Recommendation Report for Prior Notification for Householder Extension

REF NO: EP/99/21/PDH

LOCATION: 36 Old Worthing Road
East Preston
BN16 1DZ

PROPOSAL: Notification under extended permitted development rights for a single storey rear extension measuring 6m from beyond the rear wall of the original dwelling house, with maximum height of 3m and eaves height of 3m.

1498/P02 A

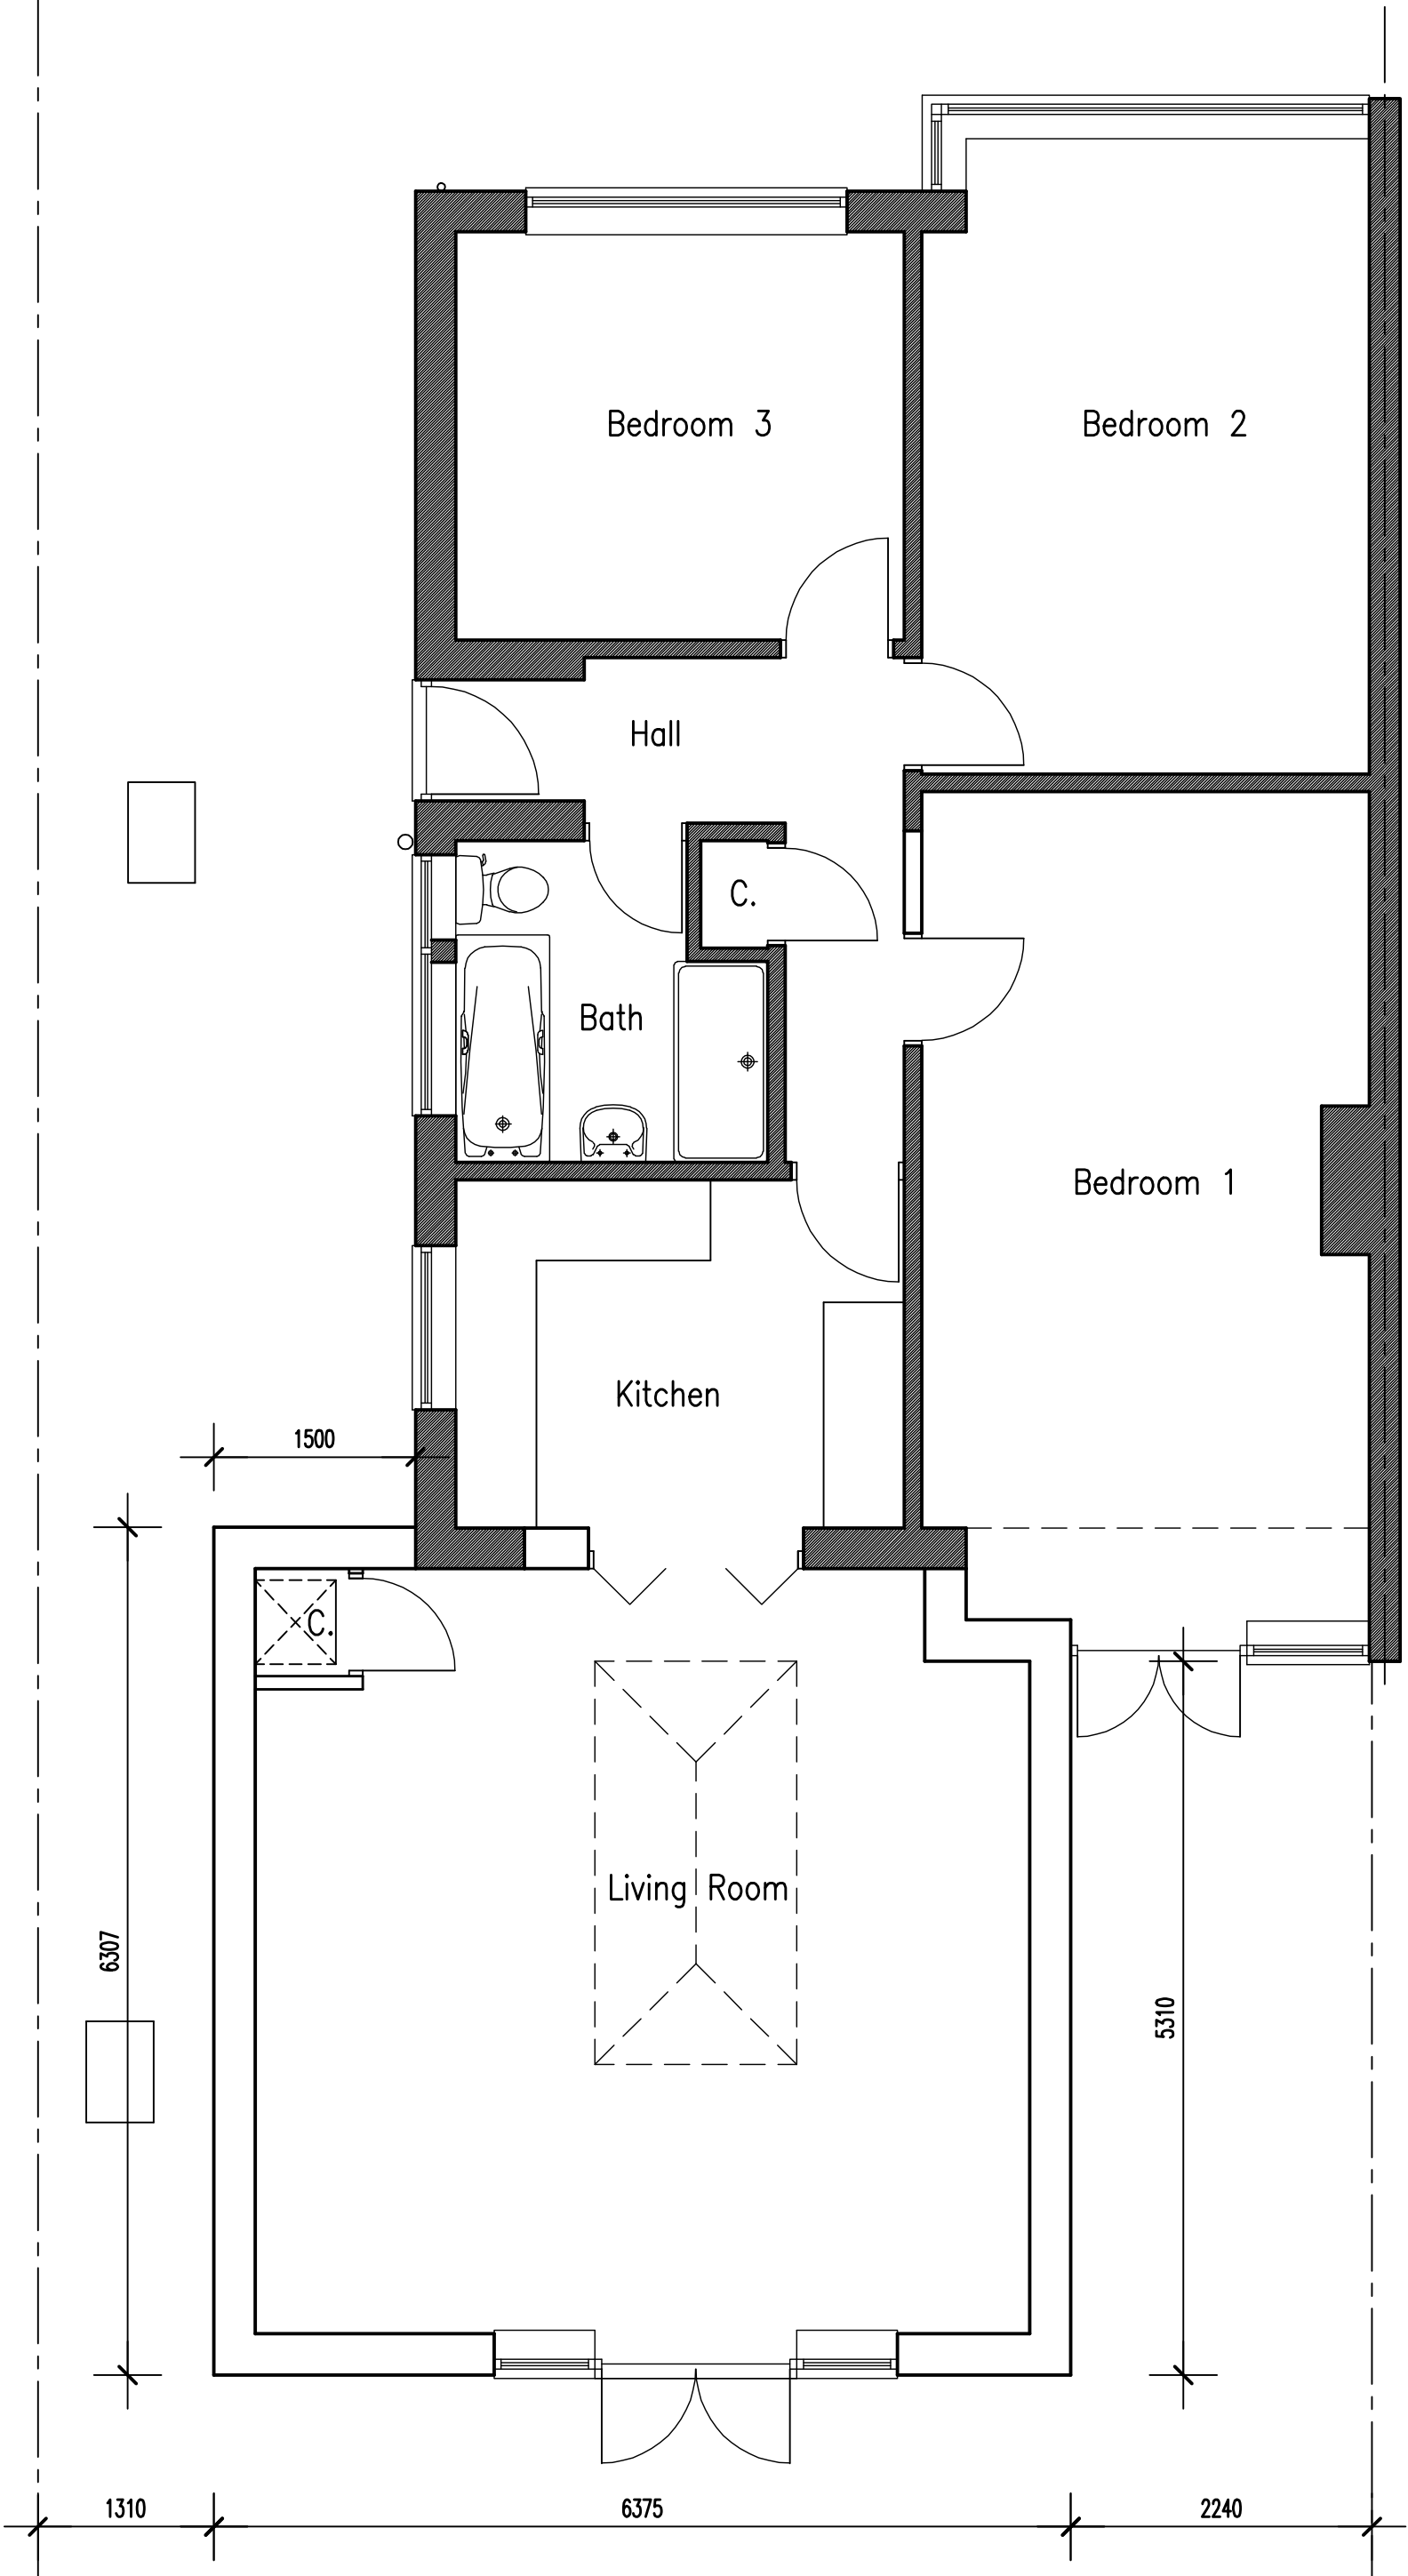
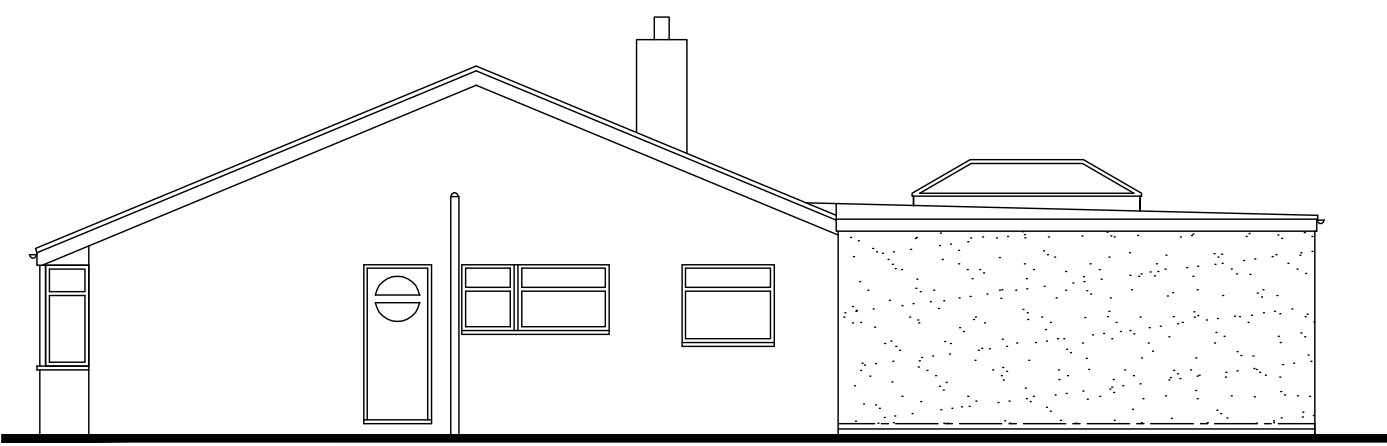
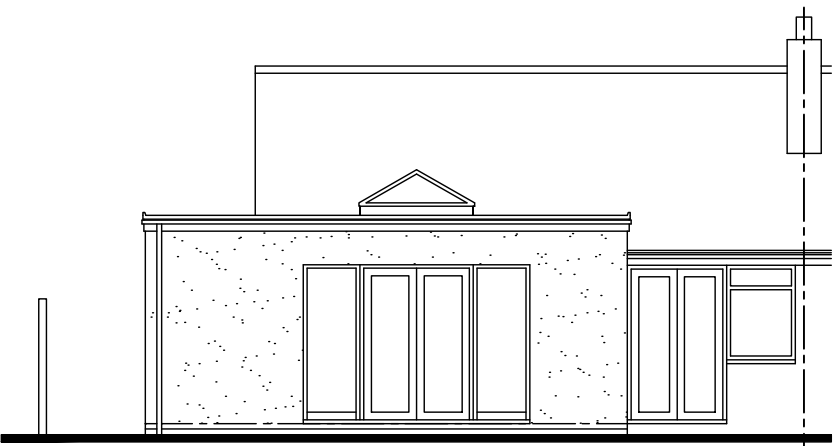
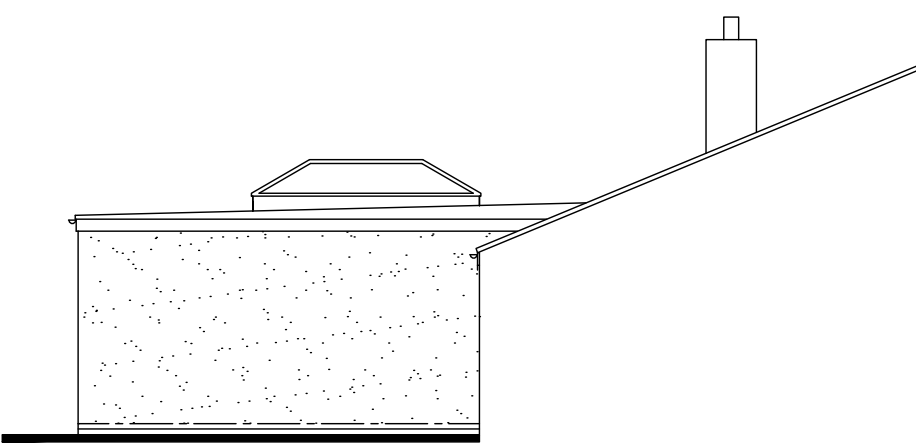
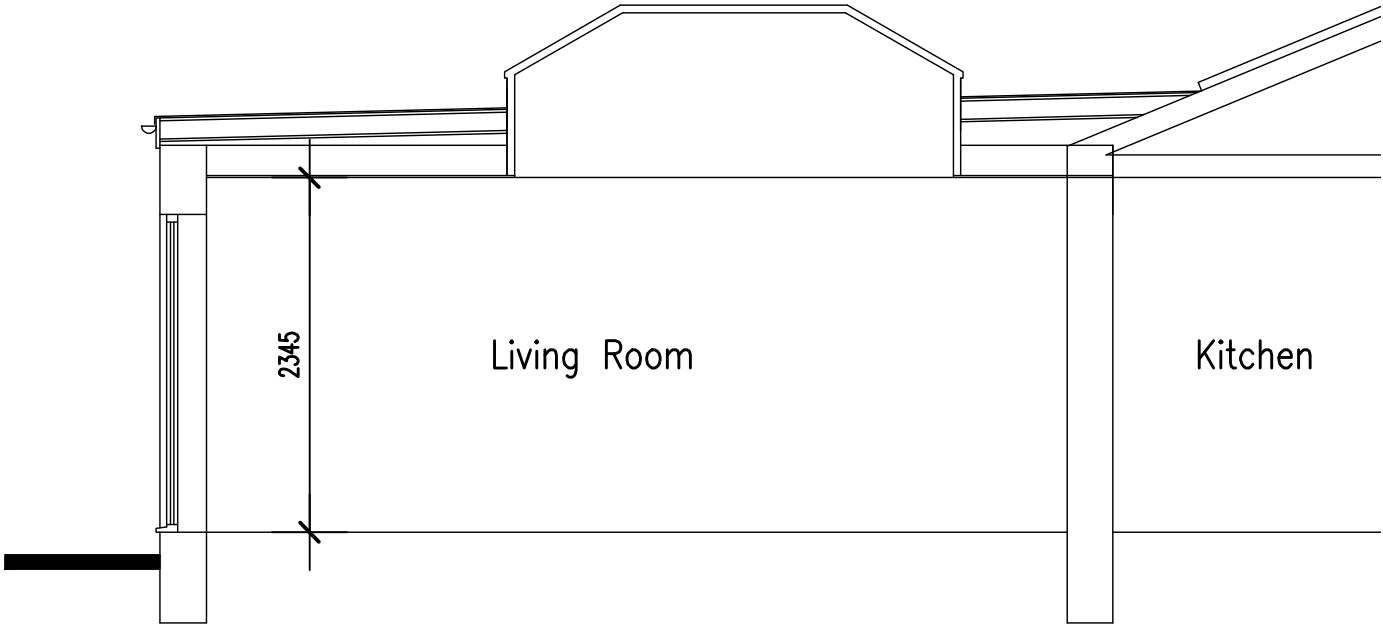
The proposed extension would be a rear and side extension, which would encroach on the separation distances between dwellings to 1.3m with the property to the West and 2.24m to the East.

The extension would be higher than the existing eaves line by approximately 150mm and have a total height of 3.1m above NGL.

The 45-degree rule would be breached by the extension but it is believed not to be by a great amount.

The proposed extension forms both a side and rear extension of a semi-detached dwellinghouse, and at 6.37m has a width greater than that of the original dwellinghouse contrary to Class A (j) (iii). Additionally

the eaves height of the proposed would be higher than the existing eaves height contrary to Class A (d).

Extends forms both a side and rear extension of a semi-detached dwellinghouse, and at 6.37m has a width greater than that of the original dwellinghouse contrary to Class A (j) (iii). Additionally the eaves height of the proposed would be higher than the existing eaves height contrary to Class A (d).
